ENG-SF21026-R3-CDs.pdf Markup Summary

RD05

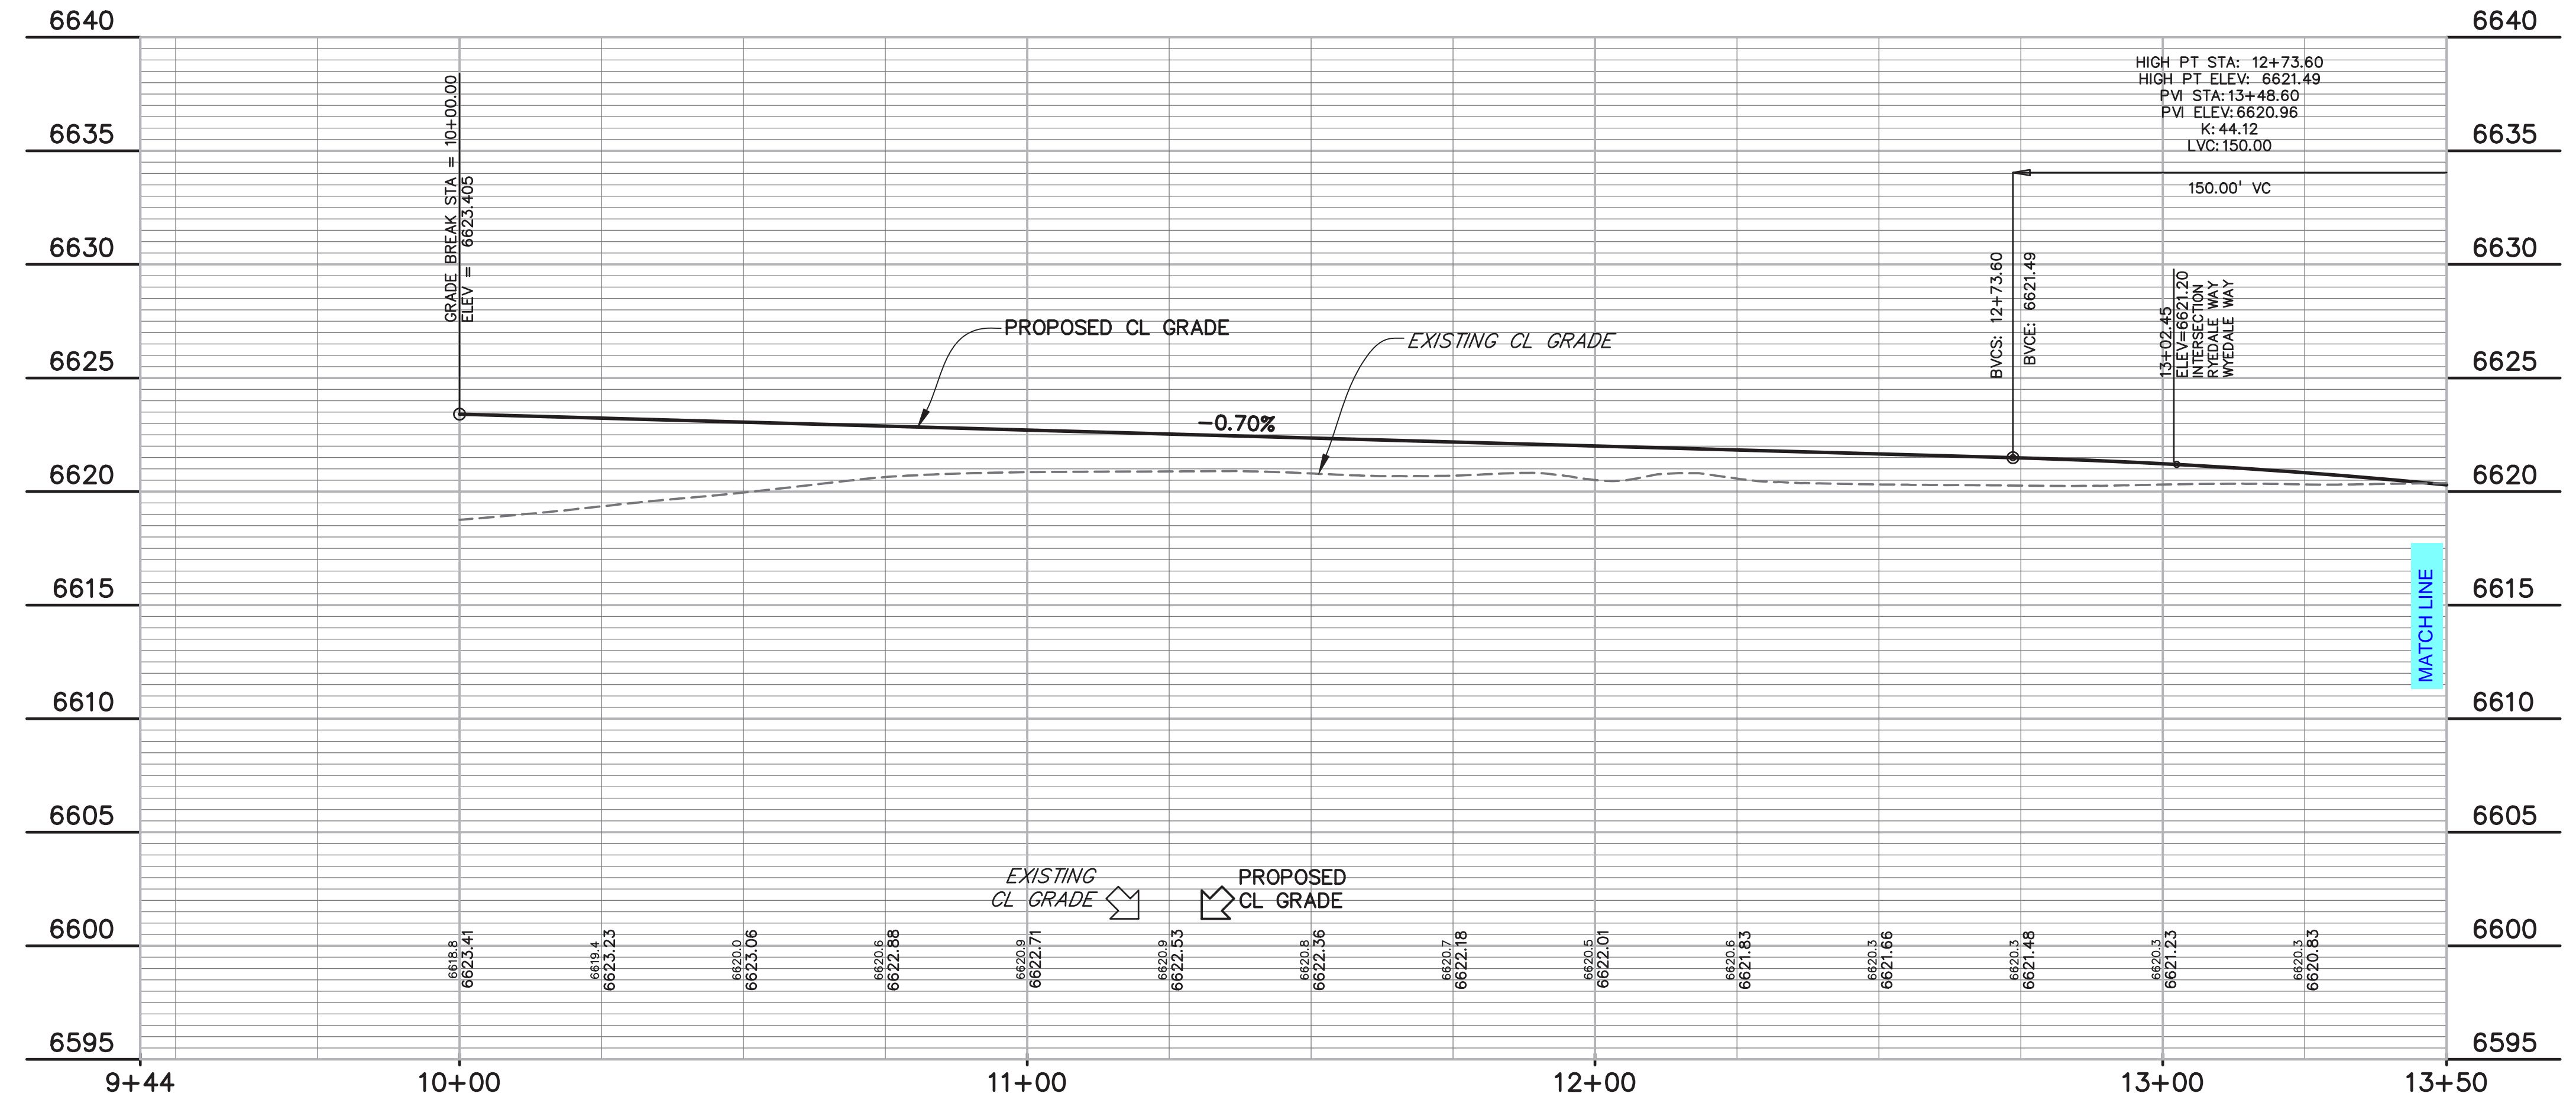
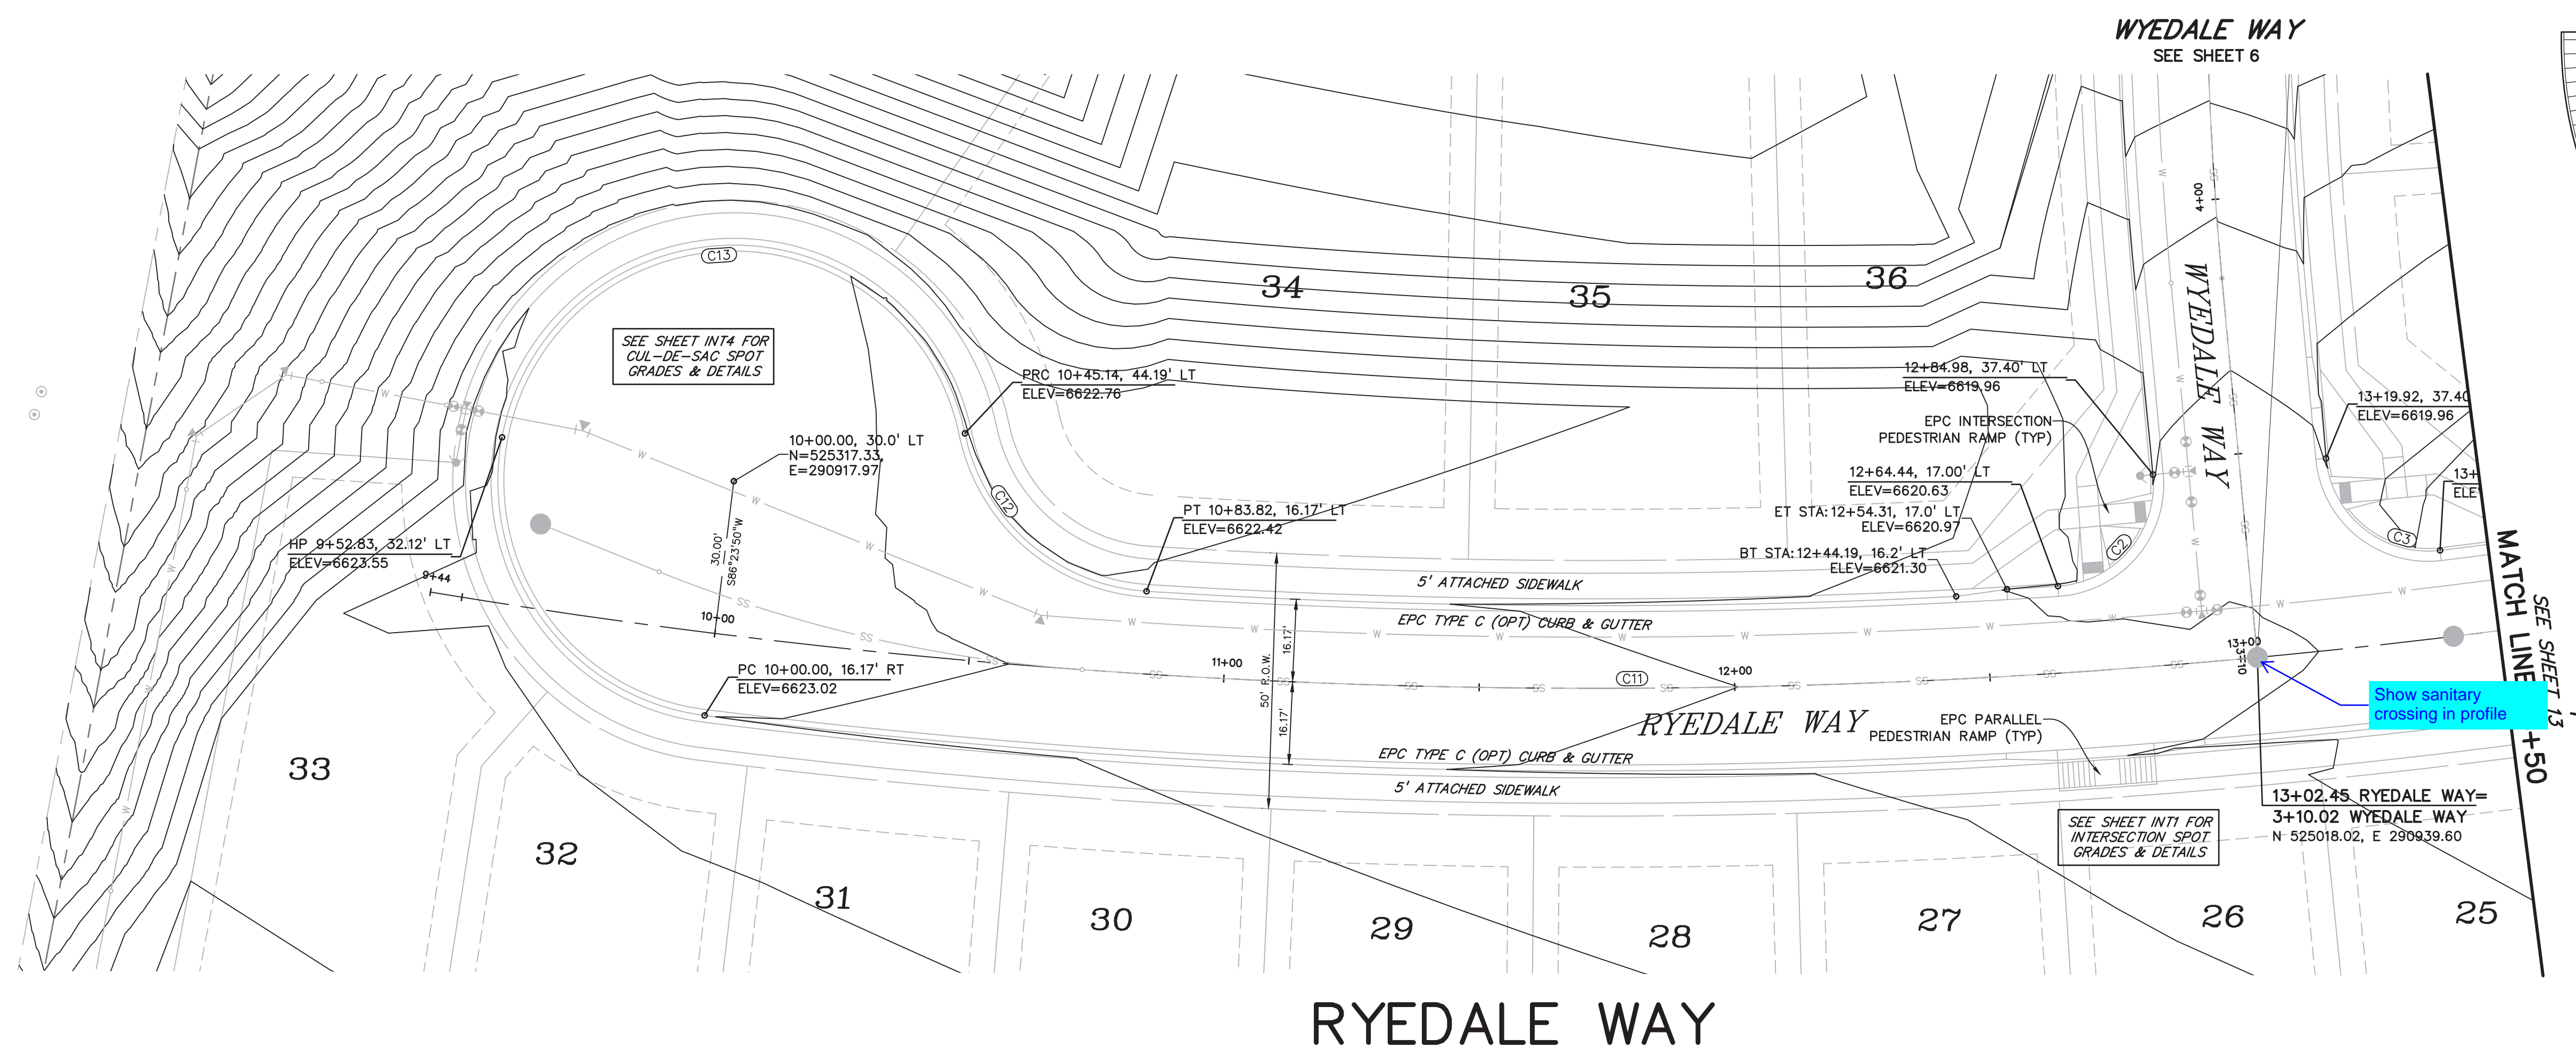
Fix overlapping text

Separate profile for storm laterals.

**RYEDALE WAY
 PLAN AND
 PROFILE**

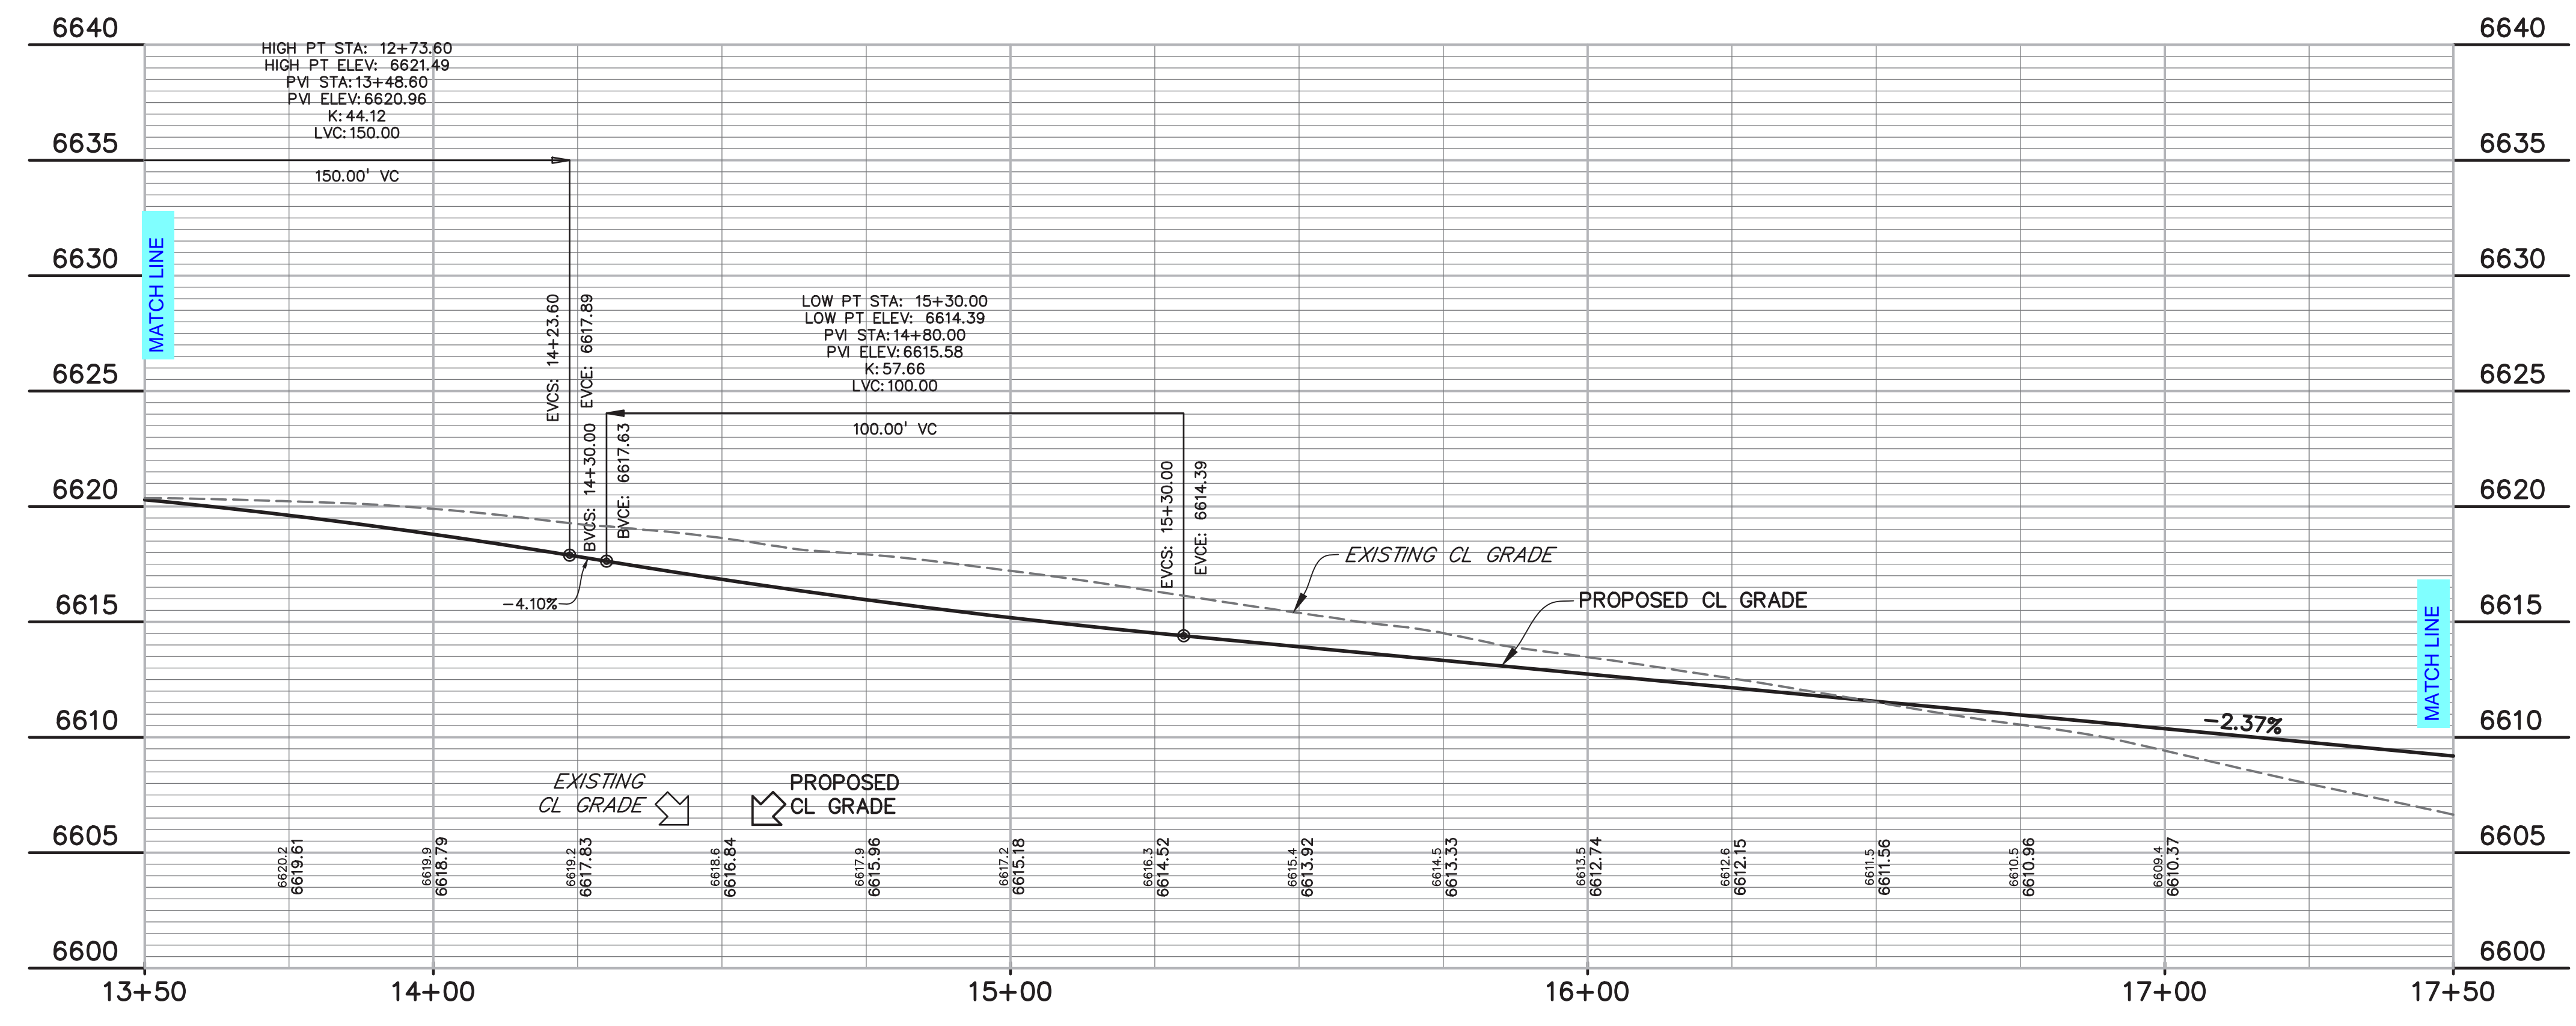
Show water and sanitary crossings in profile

Separate profile for storm.

Tract?

RD08

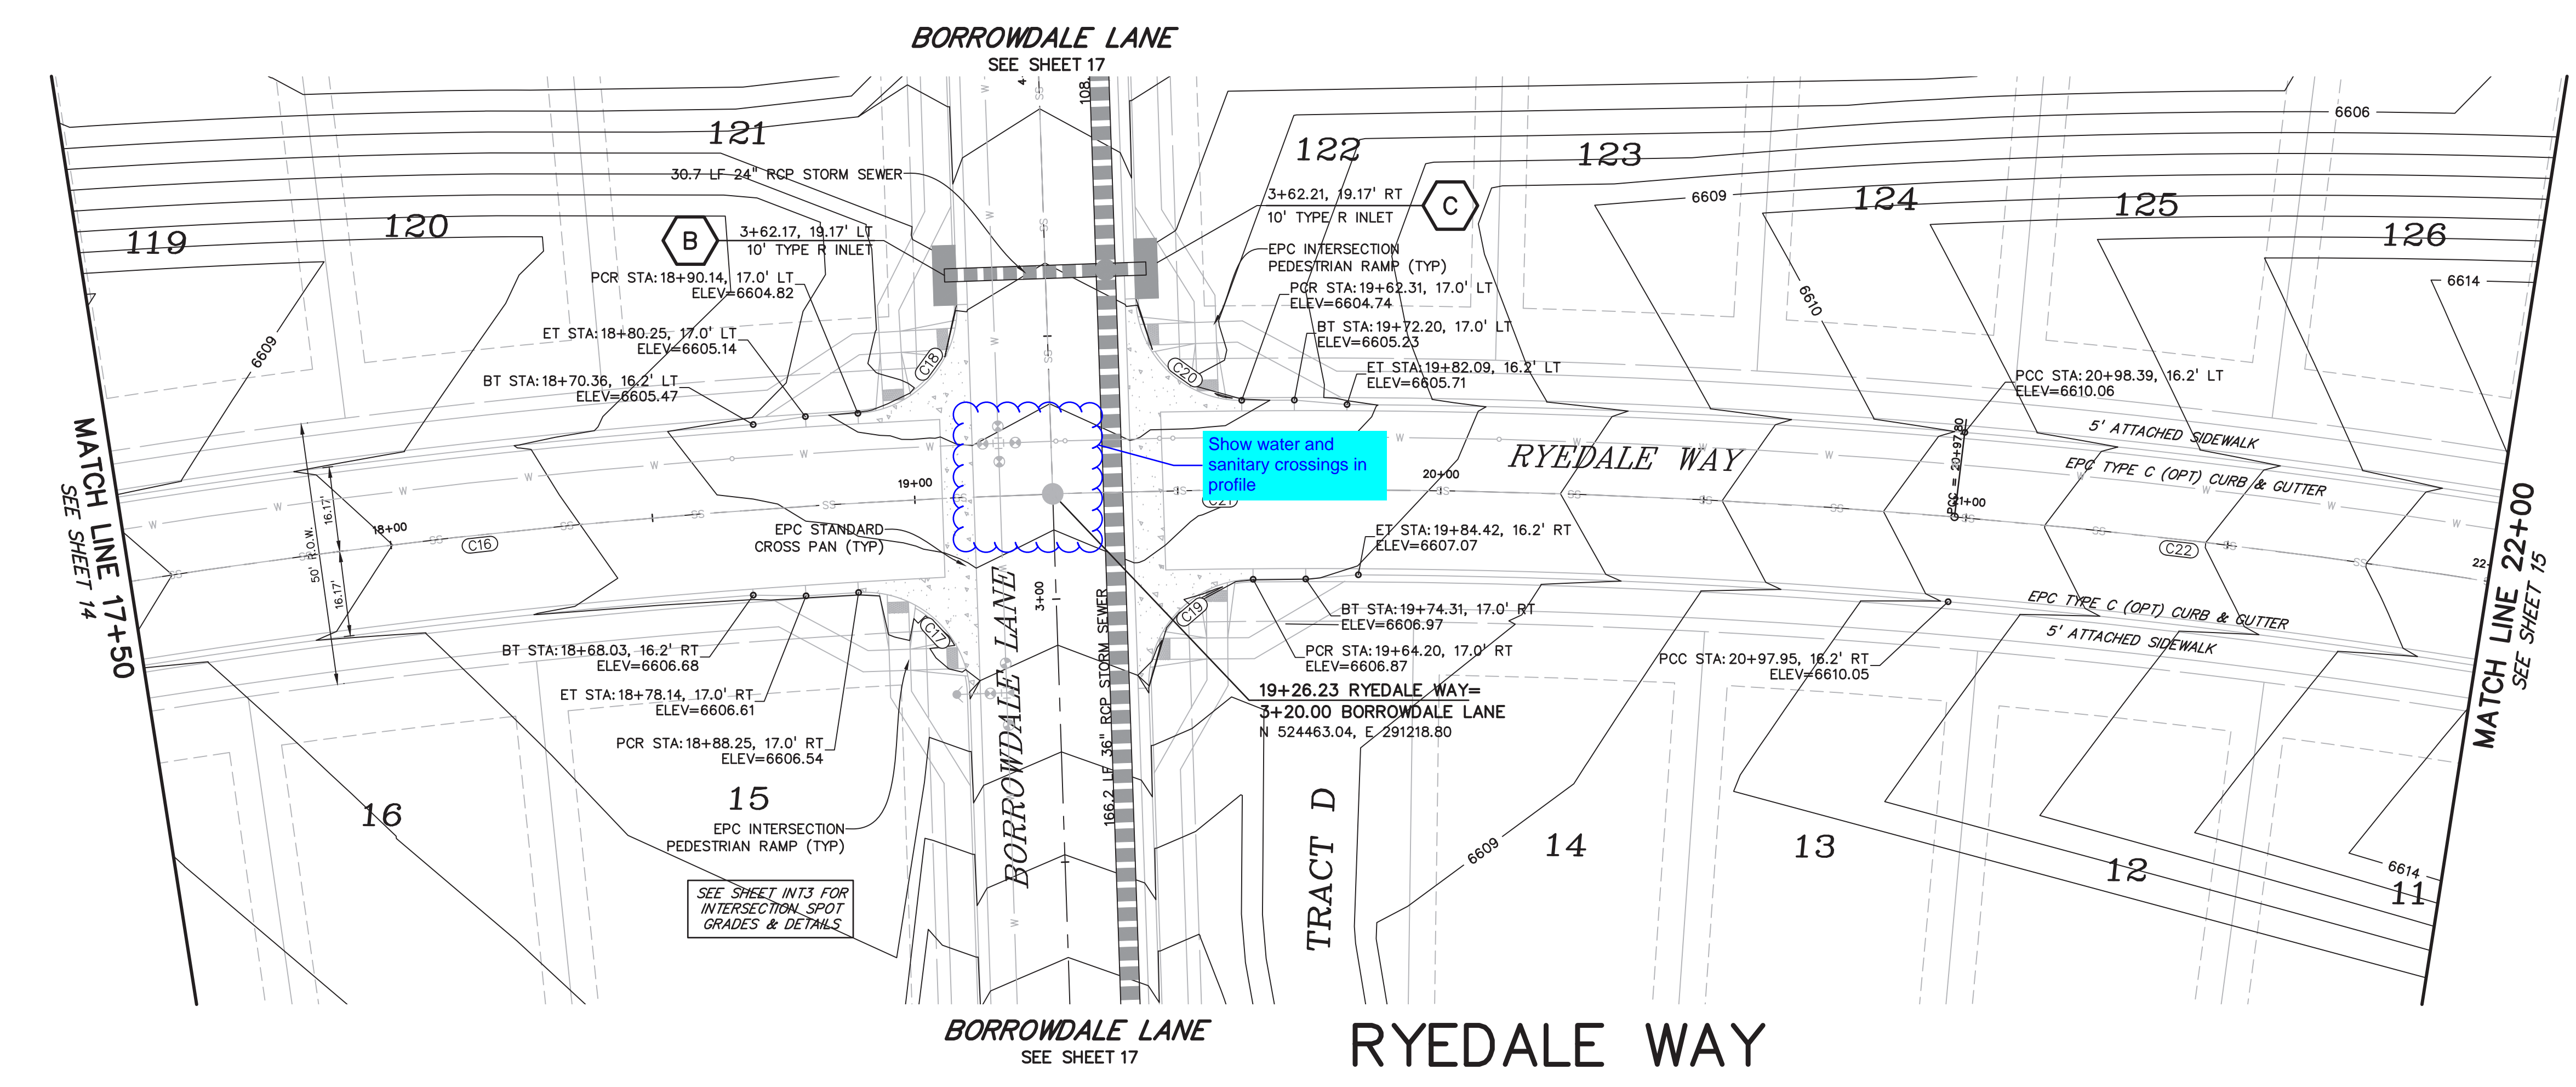
Show sanitary crossing in profile
